Gatwick Airport Northern Runway Project

The Applicant's Response to Deadline 7 Submissions

Application Document Ref: 10.65

Figure 4.4: Schematic Drawing of the proposed Car Park X FCA

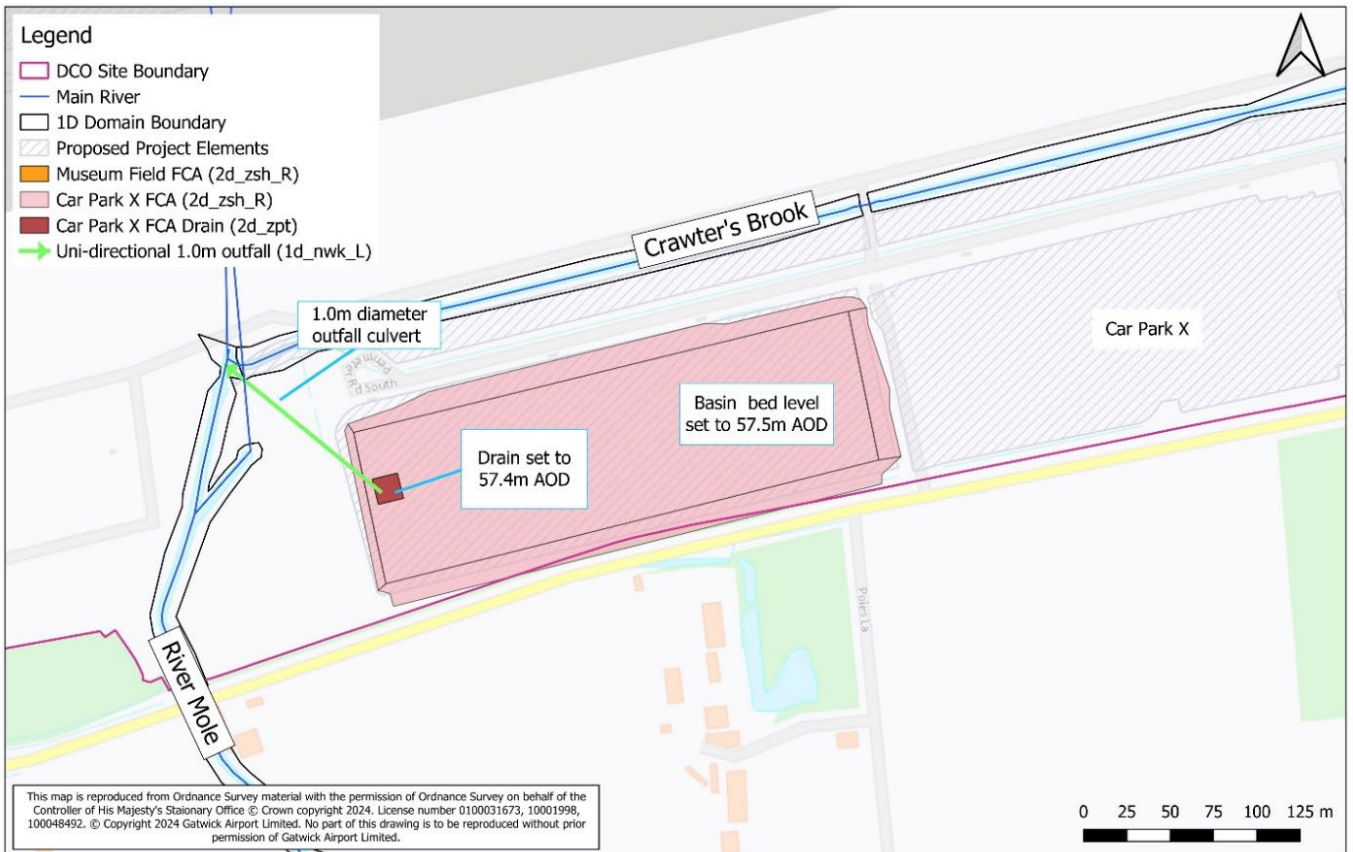
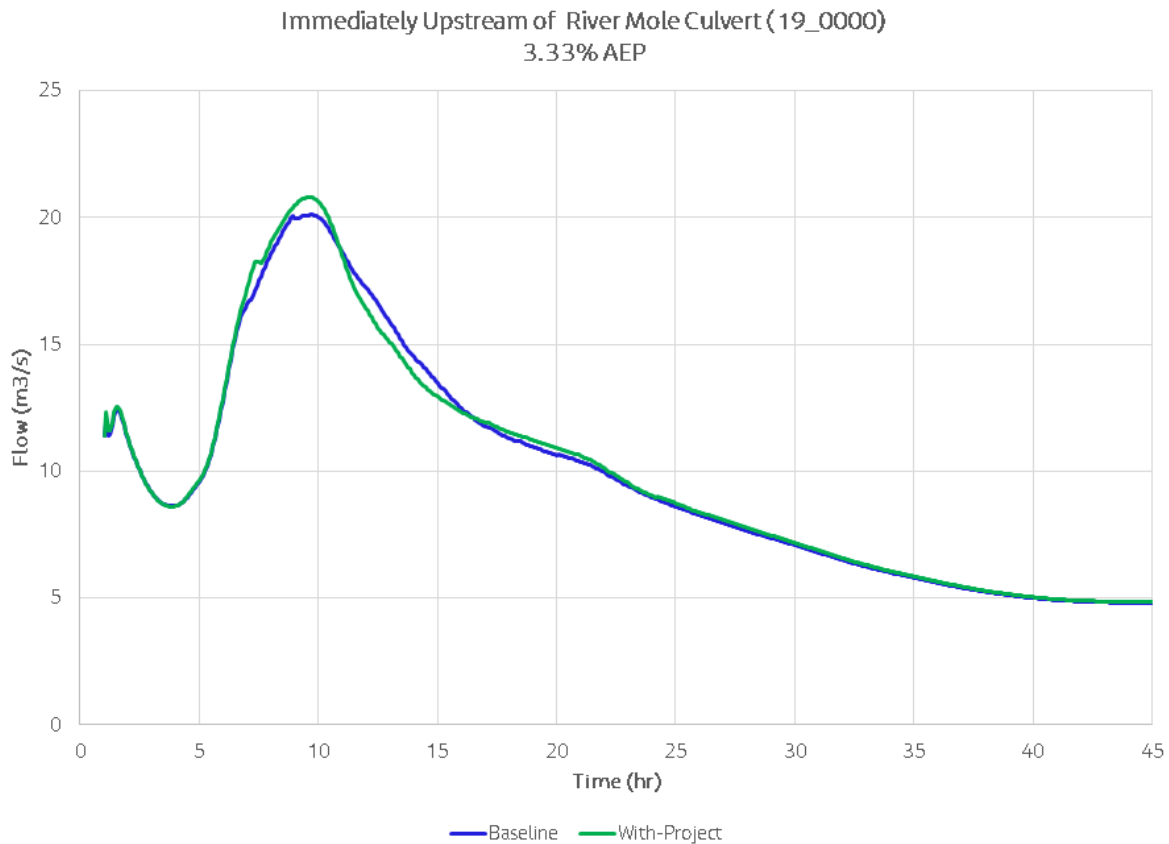
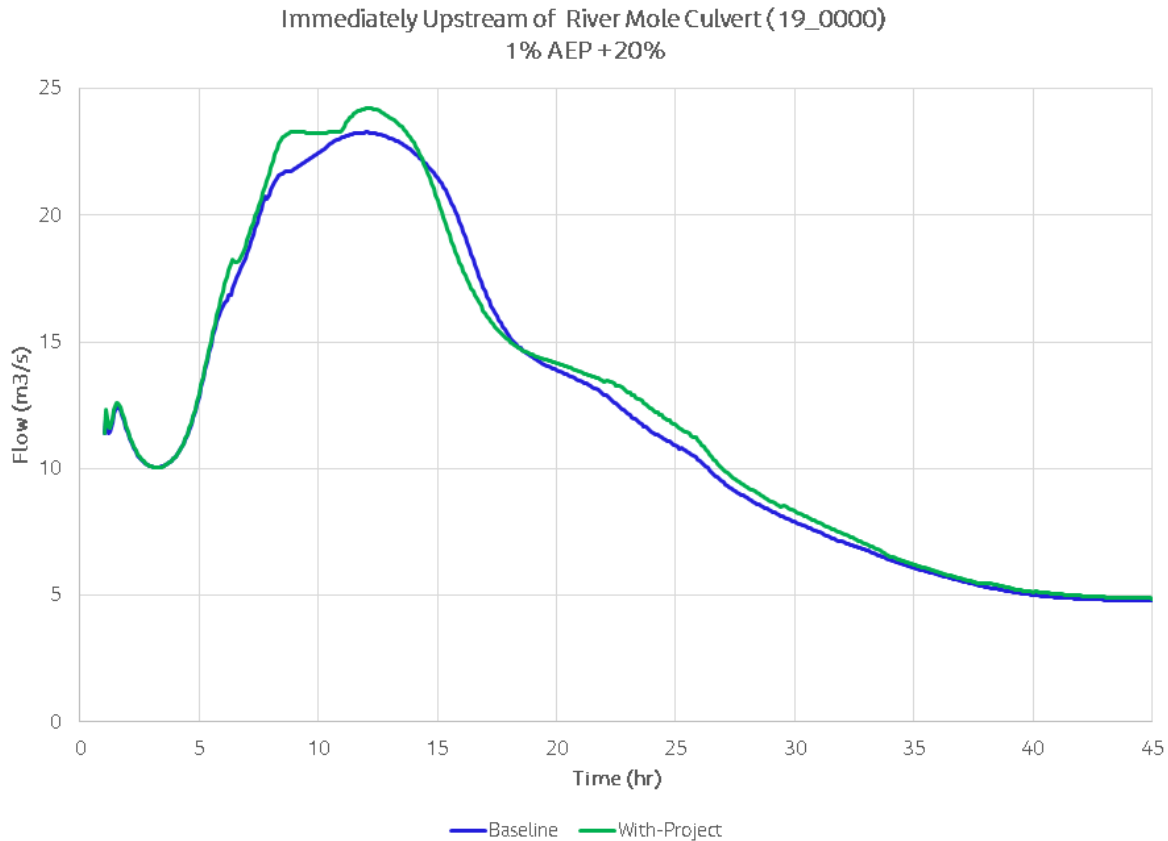
<p>Section 7 of the FRA contains information around the flood mitigation features to be included, with signposting given to ES Appendix 11.9.6: Annex 5 for some further outline details on the proposed Flood Compensation Areas (FCAs) at Museum Field and Car Park X. It is noted that the presence of the</p>	<p>Paragraph 6.2.13 of ES Appendix 11.9.6: Annex 5 Fluvial Model Build Report [REP5-027] indicates the increase in peak flows downstream of Car Park X FCA are likely due to the attenuation of the FCA to allow for the River Mole culvert to flow more efficiently, resulting in the increase in flows. However, this could not extend</p>

<p>FCA at Car Park X appears to increase peak flows downstream of this FCA. It is suggested the presence of the Museum Field FCA further downstream would capture this increase in flows so overall, the flood risk elsewhere would not be increased. It would be helpful to understand more about why the flows downstream would be subject to increase with the Car Park X FCA in place, and whether any measures can be incorporated into the design of the FCA at Car Park X to negate the suggested increase in flows.</p>	<p>further downstream beyond the Museum Field FCA and would not affect other parties as part of the holistic mitigation strategy for the whole Project.</p>
	<p>The FRA should also consider whether the introduction of the FCAs on the River Mole would result in any impact on flood peaks travelling further down the River Mole, especially after the confluence of the River Mole and the Gatwick Stream. As water will be attenuated in both Car Park X and Museum Field, is there likely to be any impact on the coincidence and timing of flood peaks from the Gatwick Stream and River Mole as they travel further along the River Mole downstream of the Airport?</p>	<p>The Upper Mole (UM) model has been used to determine the fluvial flood risk baseline and the potential impacts of the NRP. The model extends approximately 1.5km downstream of the NRP boundary which is considered sufficient to fully assess any potential downstream effects. Figures 7.2.3, 7.2.4, 7.2.5 and 7.2.6 in ES Appendix 11.9.6: Flood Risk Assessment [REP6-052] indicate the Project would not increase flood depths to other parties including those downstream. As an example, the hydrograph below demonstrates no increase to peak flows at minimal change to the timing of the peak in the River Mole at the downstream model boundary for the Credible Maximum Scenario.</p>
